From: Joanne Lewis
Sent: 05 June 2019 14:14
To: Planning.Responses
Cc: Anna Appleton
Subject: RE: Planning Consultation on Y/48/19/DOC

APPLICATION Y/48/19/DOC
NO:

Registered: 29-MAY-19
Site Address: Cinders Lane Nursery And Works To The Rear Cinders Lane
Yapton BN18 0JJ

Approval of details reserved by condition imposed under Y/5/17/OUT relating to Condition Nos 9 - Construction Management Plan and 10 - contamination of the site.

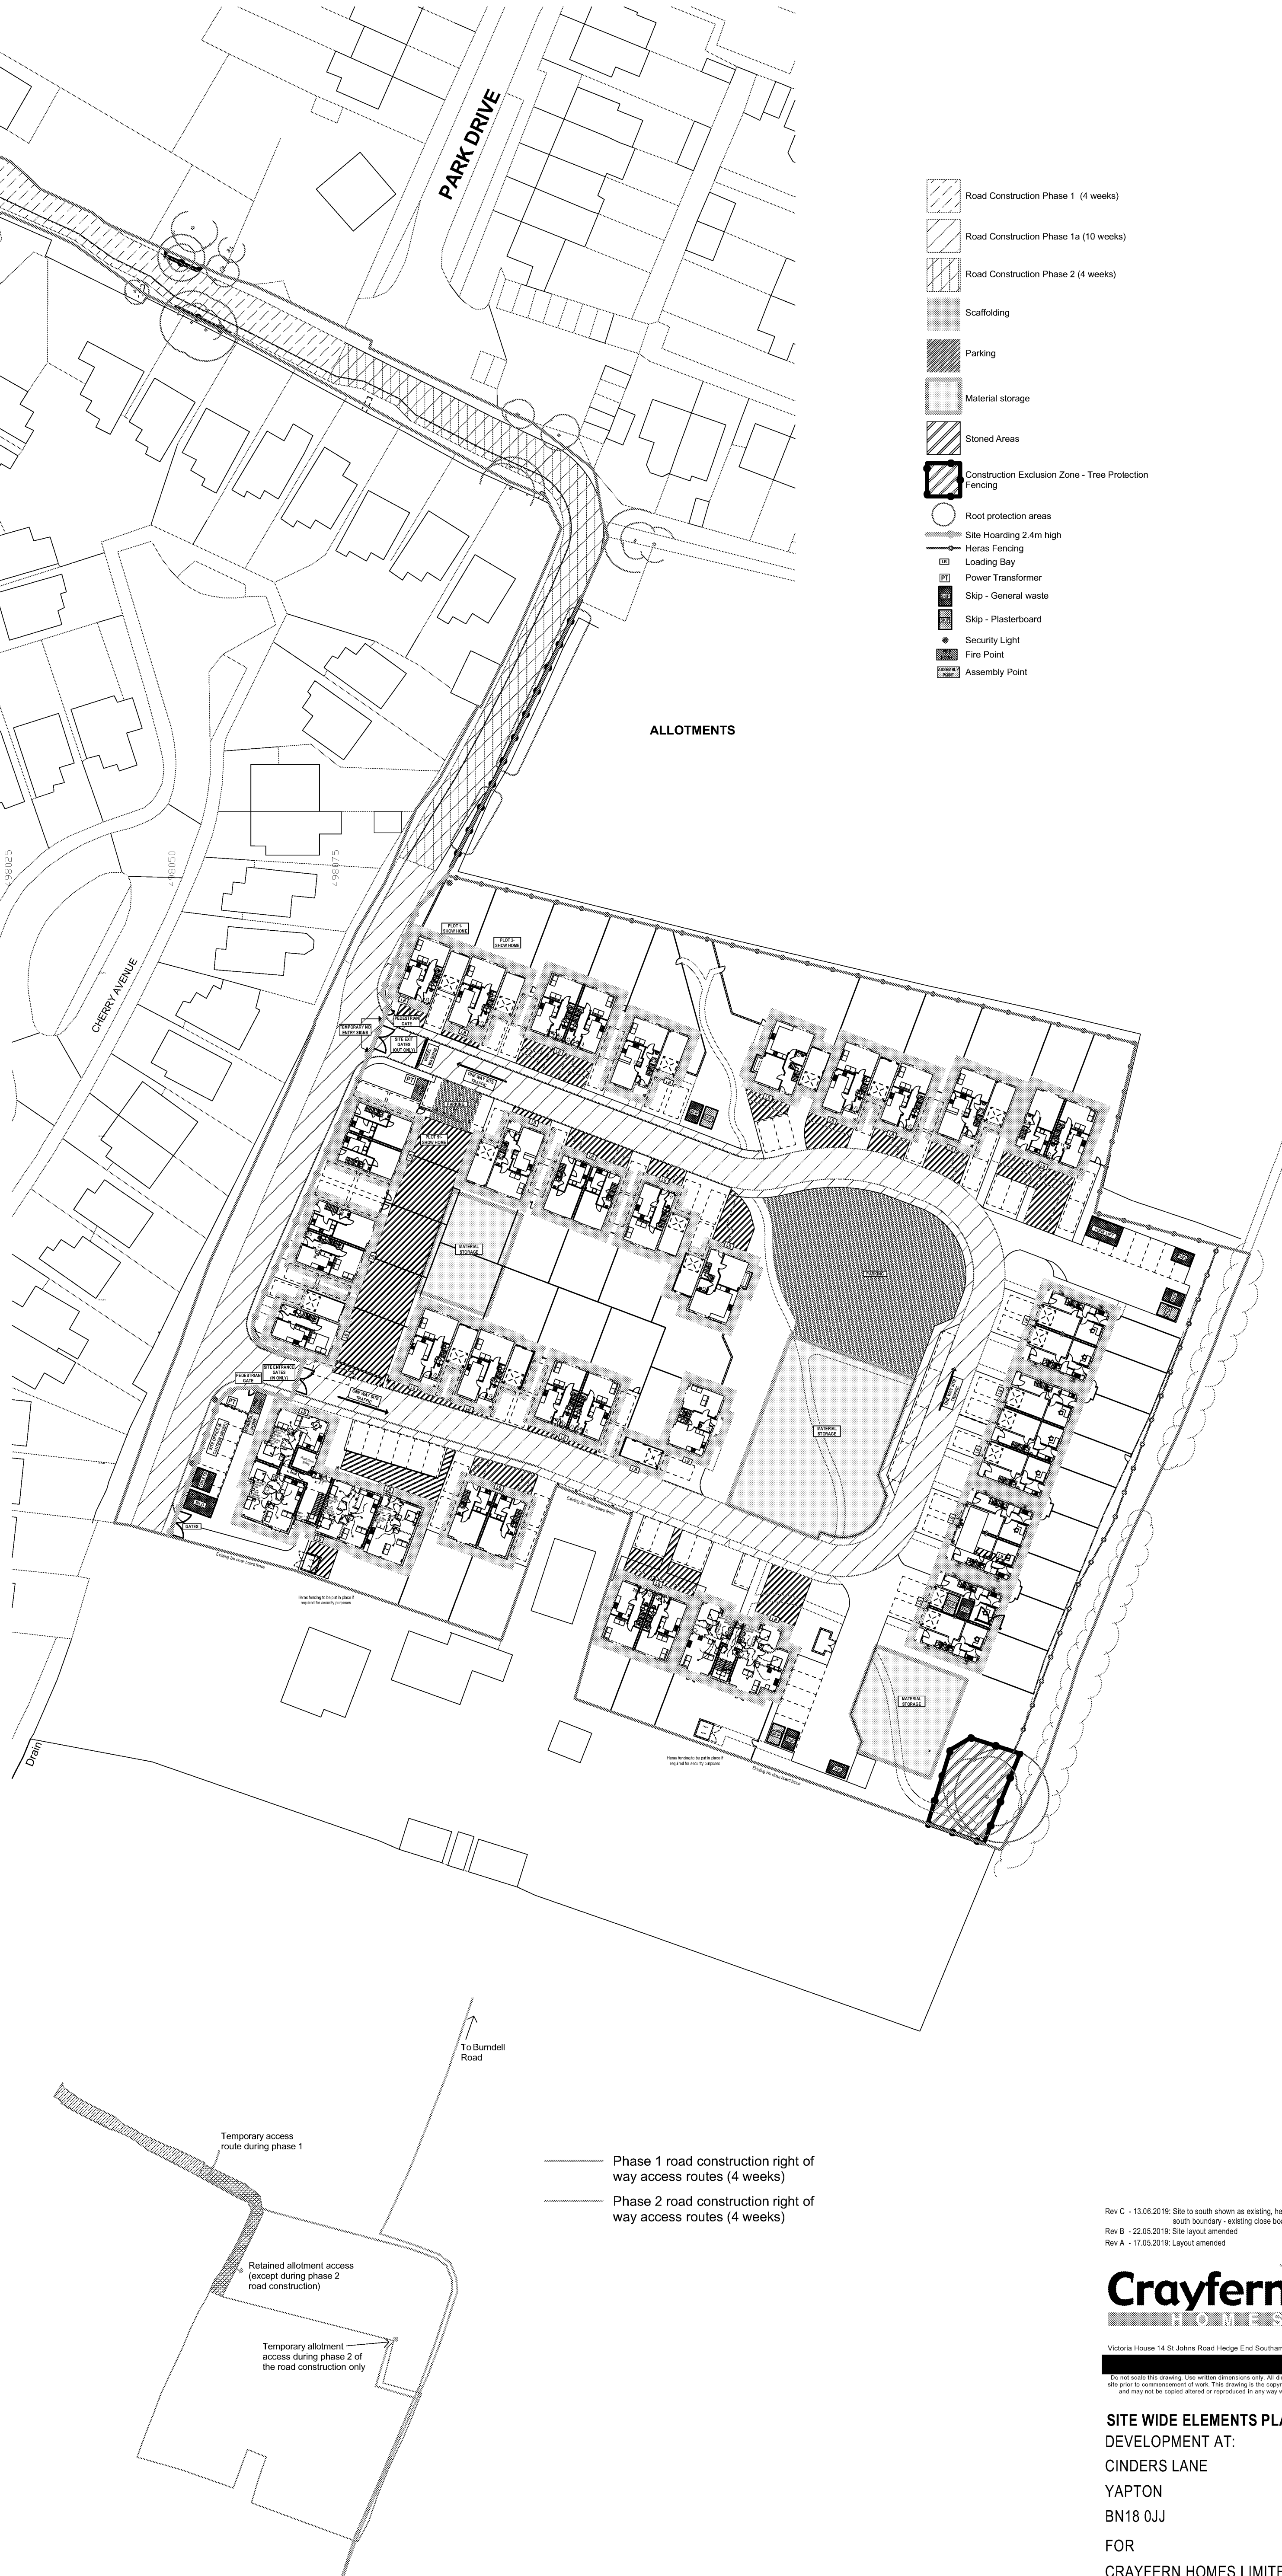
Condition Nos; 9 - Construction Management Plan - this is generally acceptable but I would request that 2.4m hoarding is installed along the site boundary where it adjoins existing residential property. Heras fencing gives no protection to the existing residents from noise or dust on the development site.
